CITY OF ALBUQUERQUE

Re: 2500 Carlisle Development
2500 Carlisle Blvd. NE
Traffic Impact Study-draft, HT#H17D002A
Report dated July 2021
Engineer's Stamp -----
Via email jkruse@lee-eng.com

The subject Draft Site Traffic Analysis received on July 28, 2020, has been reviewed by the City of Albuquerque Planning Development Transportation Section. The City has the following comments:

Figure 2. Site Plan

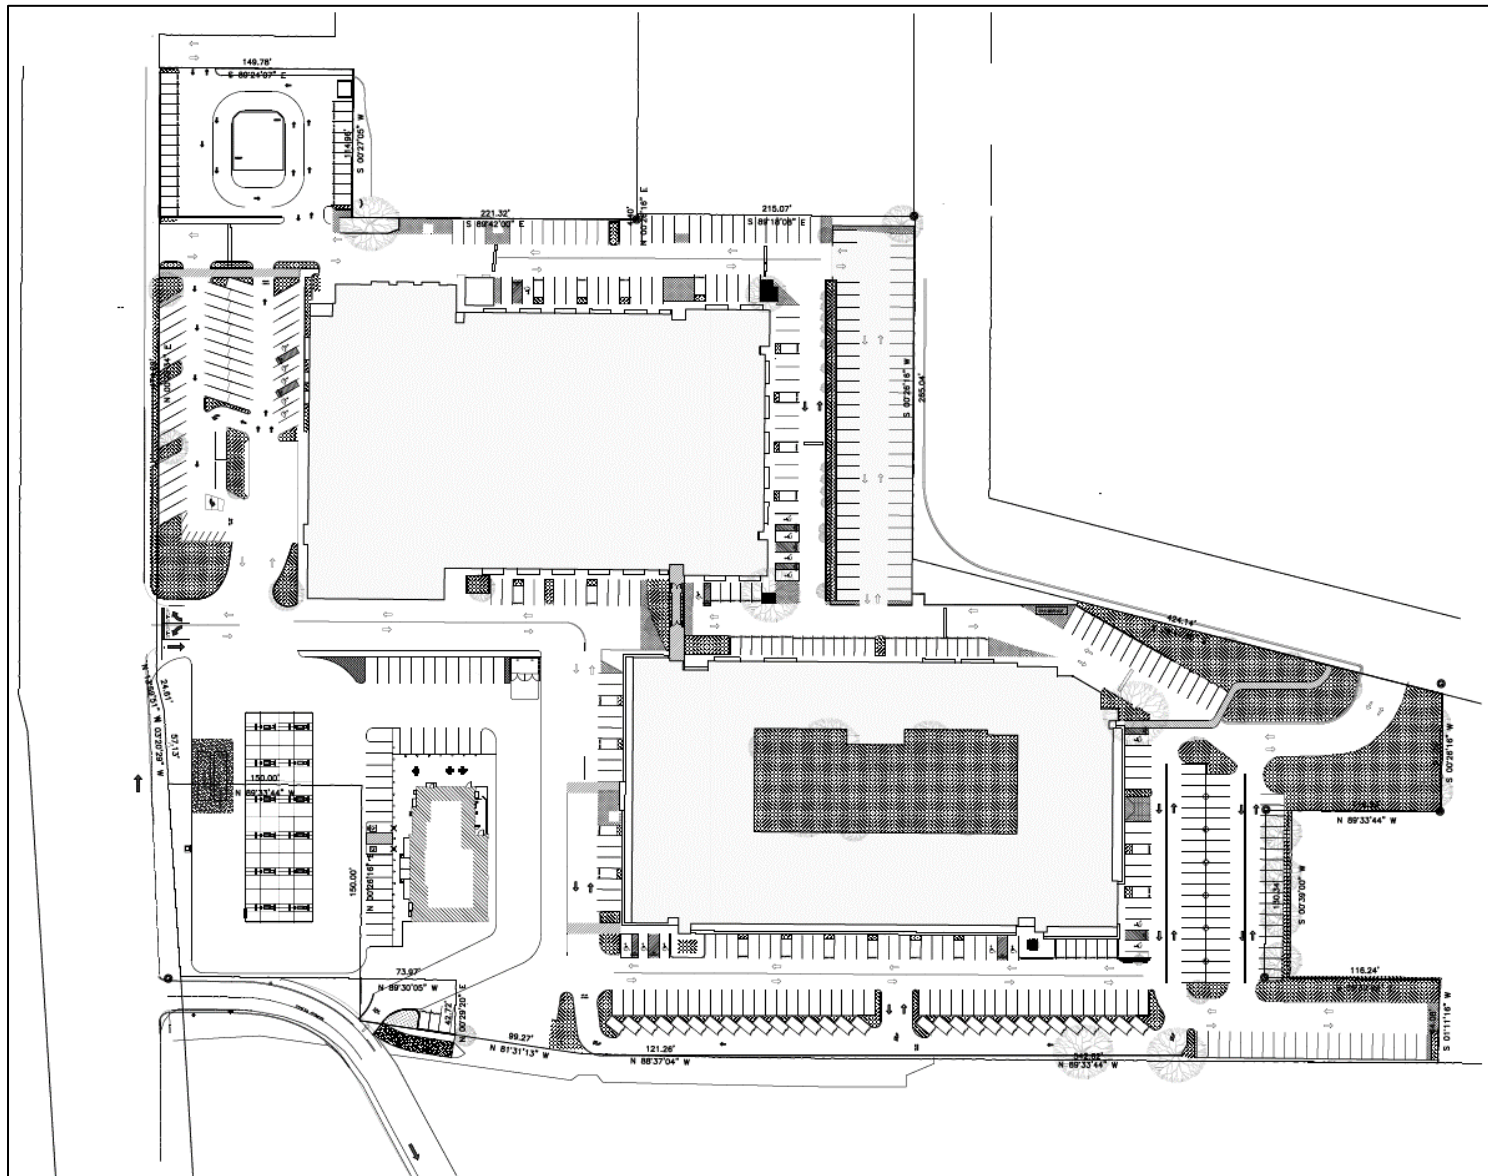
- North Driveway 1:
 - Investigate the ROW available and determine what is required to construct the recommended right-turn lane in accordance with the COA DPM. This may require conceptual level engineering drawings.
- South Full Access Driveway 3 (Prospect):
 - Investigate the ROW available and determine what is required to construct the recommended right-turn lane in accordance with the COA DPM. This may require conceptual level engineering drawings.
